CITY OF ALBUQUERQUE

May 25, 2022

Re: **Old Coors Fish Market**
809 Old Coors SW
Traffic Circulation Layout
Architect's Stamp 05-13-2022 (L11-D069)

| SHEET NUMBER | AS-1.0 |

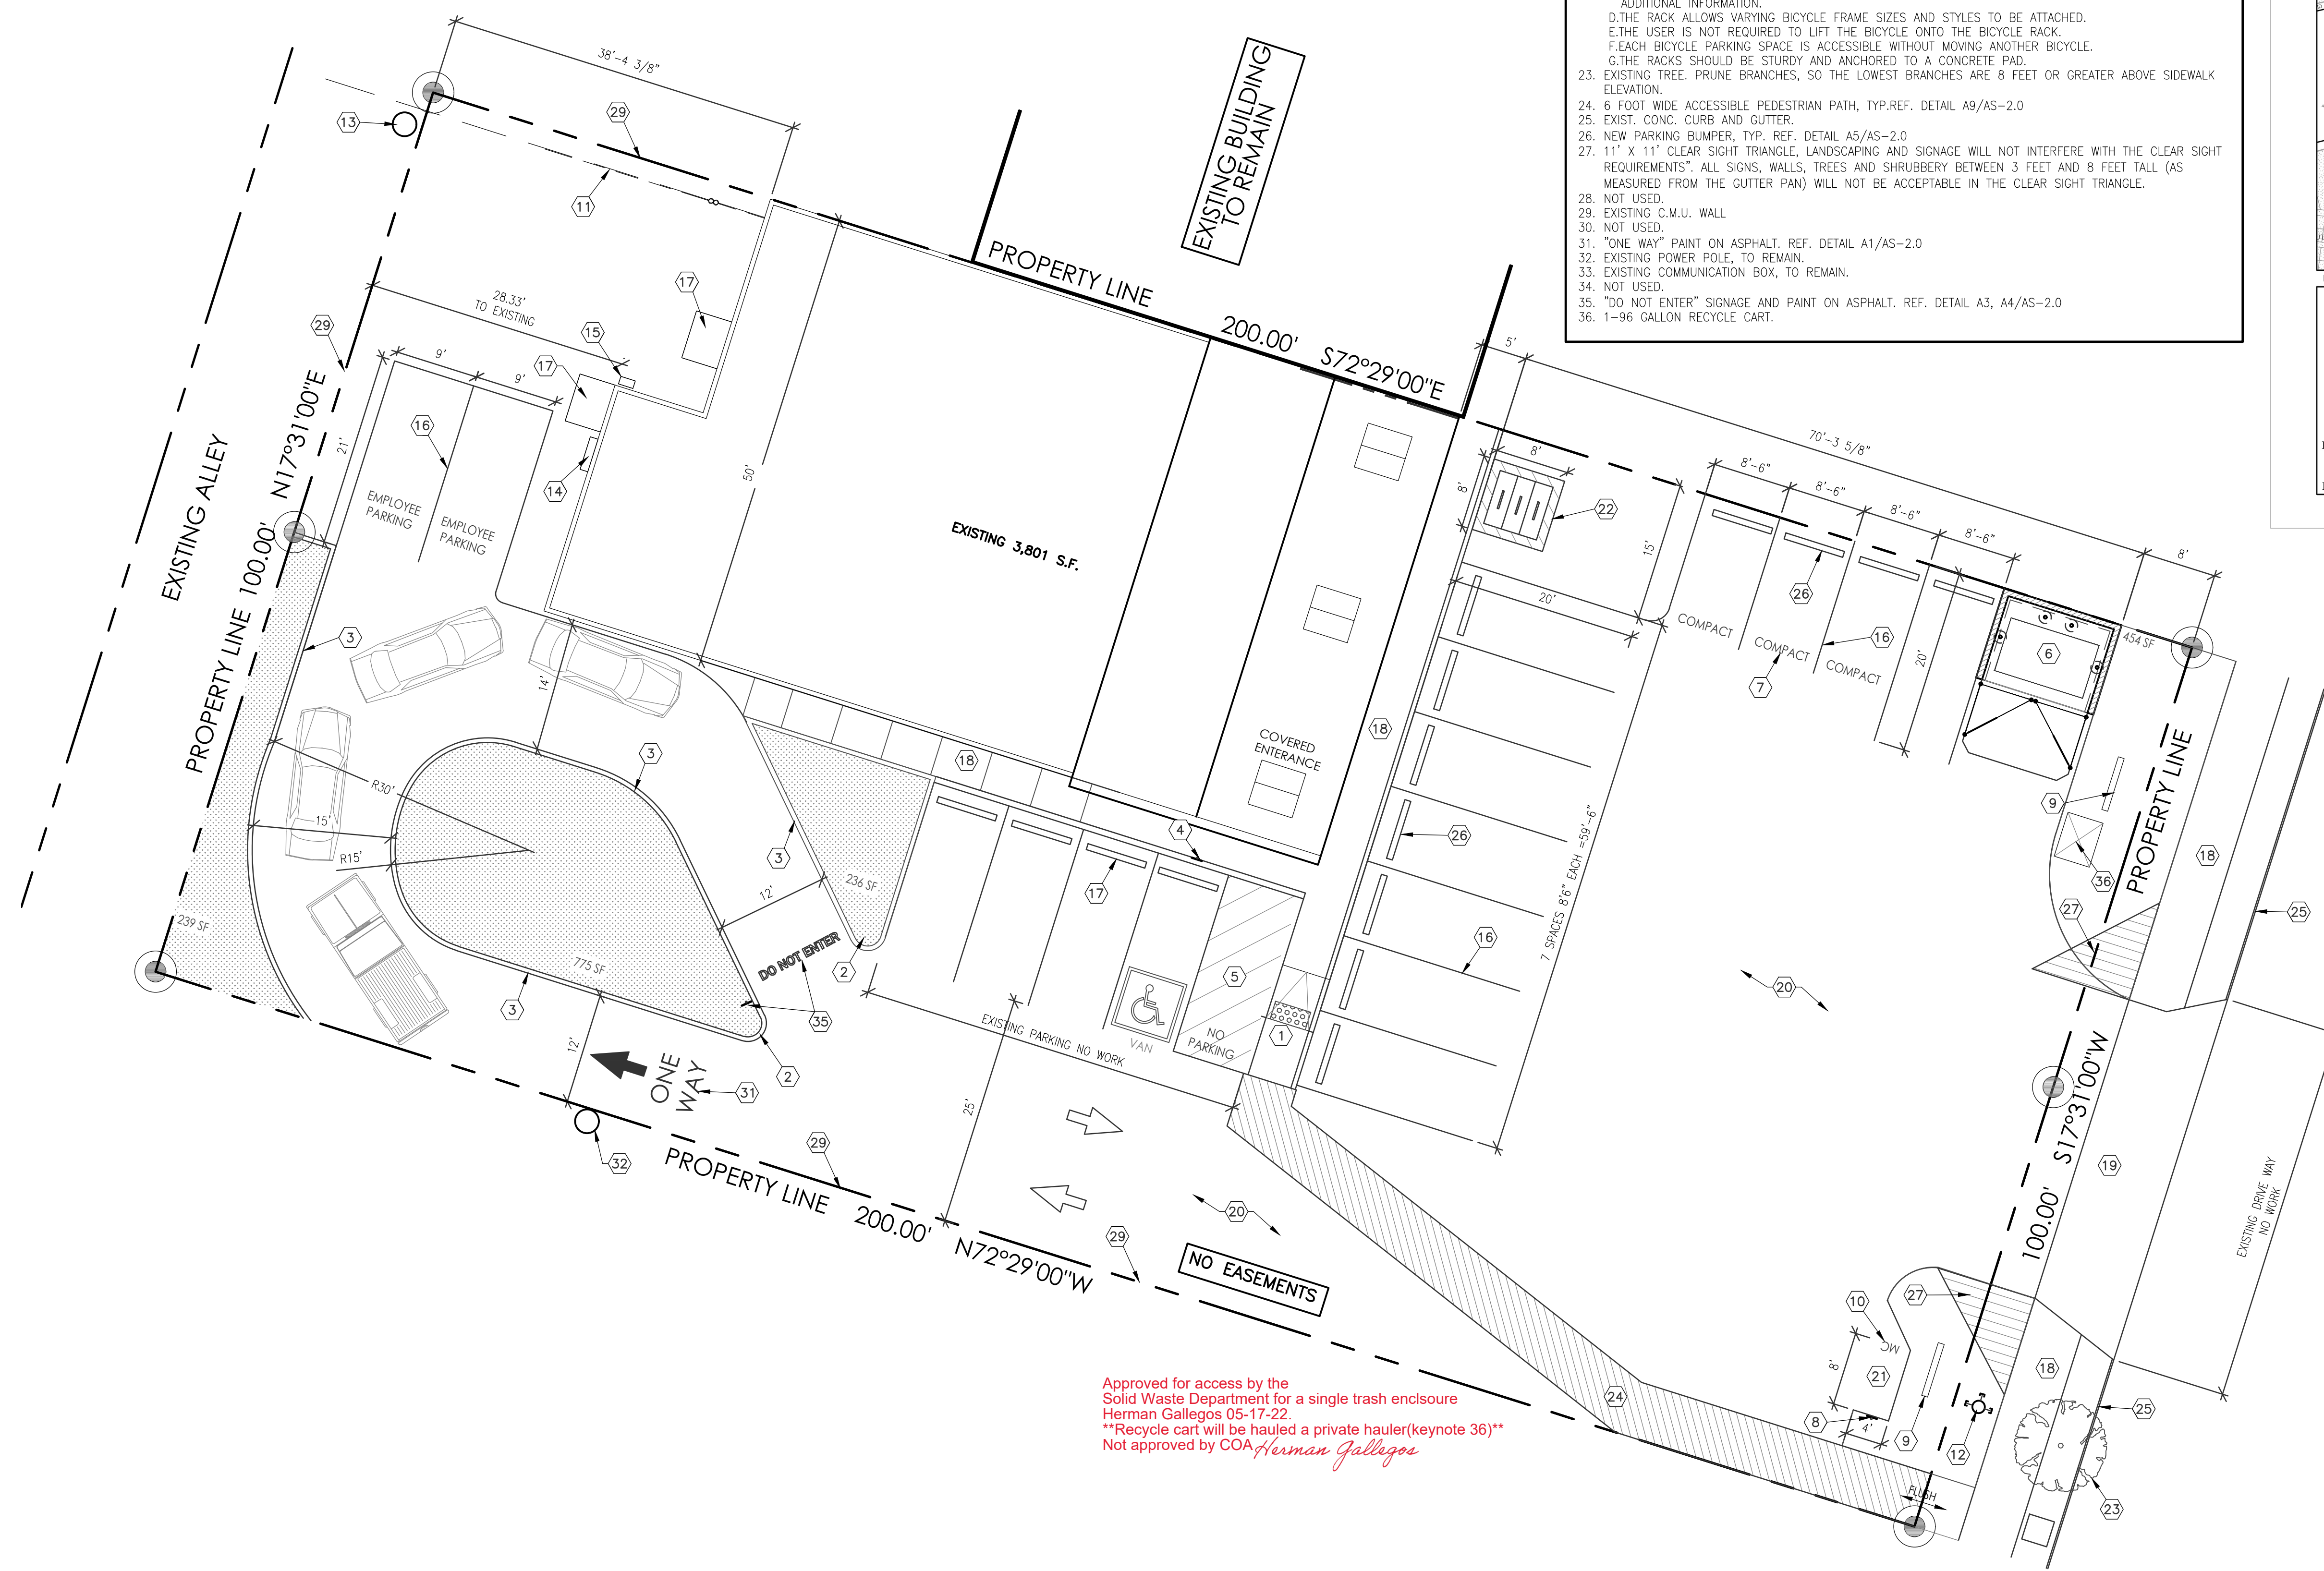
1. Listed are the number of parking spaces required by the IDO as well as the proposed number of parking spaces including bicycle and motorcycle parking.
Coordinate/discuss with Zoning.

2. Old Coors existing drivepad will need to be current/updated ADA accessible across entrance. Please verify and address appropriately. If not compliant, **replace with COA std dwg 2426 (curb return type entrance driveway).**

3. Proposed drive thru lanes are opposite of Traffic flow. This is a traffic safety issue and will need to be addressed due to the flow versus traffic consistances on vehicular movements.

4. **Keyed Note 5 & 7:** Provide detail of pavement marking text.
5. Please identify all existing buildings, **doors**, structures, sidewalks, curbs, drive pads, wall and anything that influences the parking and circulation on the site.

6. Identify the right of way width, medians, curb cuts, and street widths on Old Coors Drive.
7. Grades and slopes in the parking area and/or the ADA accessible parking areas appear to be too large. Please provide more detail(**If applicable**).

8. Please list the width and length for all existing parking spaces. Some dimensions are not shown.
9. The minimum parking stall dimensions are:

10. Compact parking spaces words "**COMPACT**": Provide text detail.
11. Parking spaces cannot be bisected by lot lines (AGIS shows lot line between parking stalls).

12. The ADA accessible spaces must include an access aisle. **Van accessible aisles should be 8ft wide;** all others should be 5ft wide. This will need to comply with the most current/updated ADA requirements.

13. The ADA accessible parking sign must have the required language per 66-7-352.4C NMSA 1978 "**Violators Are Subject to a Fine and/or Towing.**" Please call out detail and location of signs. **This will need to comply with the most current/updated ADA requirements.**

14. The ADA access aisles shall have the words "**NO PARKING**" in capital letters, each of which shall be at least one foot high and at least two inches wide, placed at the rear of the parking space so as to be close to where an adjacent vehicle's rear tire would be placed. (66-1-4.1.B NMSA 1978). **This will need to comply with the most current/updated ADA requirements.**

15. **Keyed Note 1:**
 - Provide current existing ramp detail to determine is it can be used as pedestrian pathway without any safety concerns (dimension, slopes, etc...).

- ADA curb ramps must be updated to current standards.
16. Monument Sign (north west corner of lot): Please verify that there isn't sign located at north west corner of lot as shown on AGIS. If there is a monument sign, verify that it isn't on public ROW (including air space).

17. Per DPM, a 6 ft. wide ADA accessible pedestrian pathway is required from the ADA parking stall access aisles to the building entrances. Please clearly show this pathway and provide details. **Explain the existing conditions.**

18. Per the DPM, a 6 ft. wide ADA accessible pedestrian pathway is required from the public sidewalk to the building entrances. Please clearly show this pathway and provide details and **provide shielding/curbing along the longitudinal segment of the pathway because you have vehicle traffic versus pedestrian traffic facing off in drive aisle reducing drive aisle width and pedestrian safety. This is pedestrian ADA safety issue so please address this concern.**

19. **ADA accessible pedestrian pathway should not be placed behind parking space or adjacent to a vehicular way. Vehicle and pedestrian/wheel chair conflicts should be avoided as much as possible.**

20. Curbing should be installed to delineate landscape, parking, and pedestrian ways and identify points of access. Please **call out detail and location of barrier curb.**

21. Please specify the City Standard Drawing Number when applicable.

23. Shared Site access: driveways that straddle property lines, or are entirely on one property but are to be used by another property, shall have an access easement. Please include a copy of your shared access agreement with the adjacent property owner.

24. Add a note stating "All broken or cracked sidewalk must be replaced with sidewalk and curb & gutter." A build note must be provided referring to the appropriate City Standard drawing (2430 & 2415A).
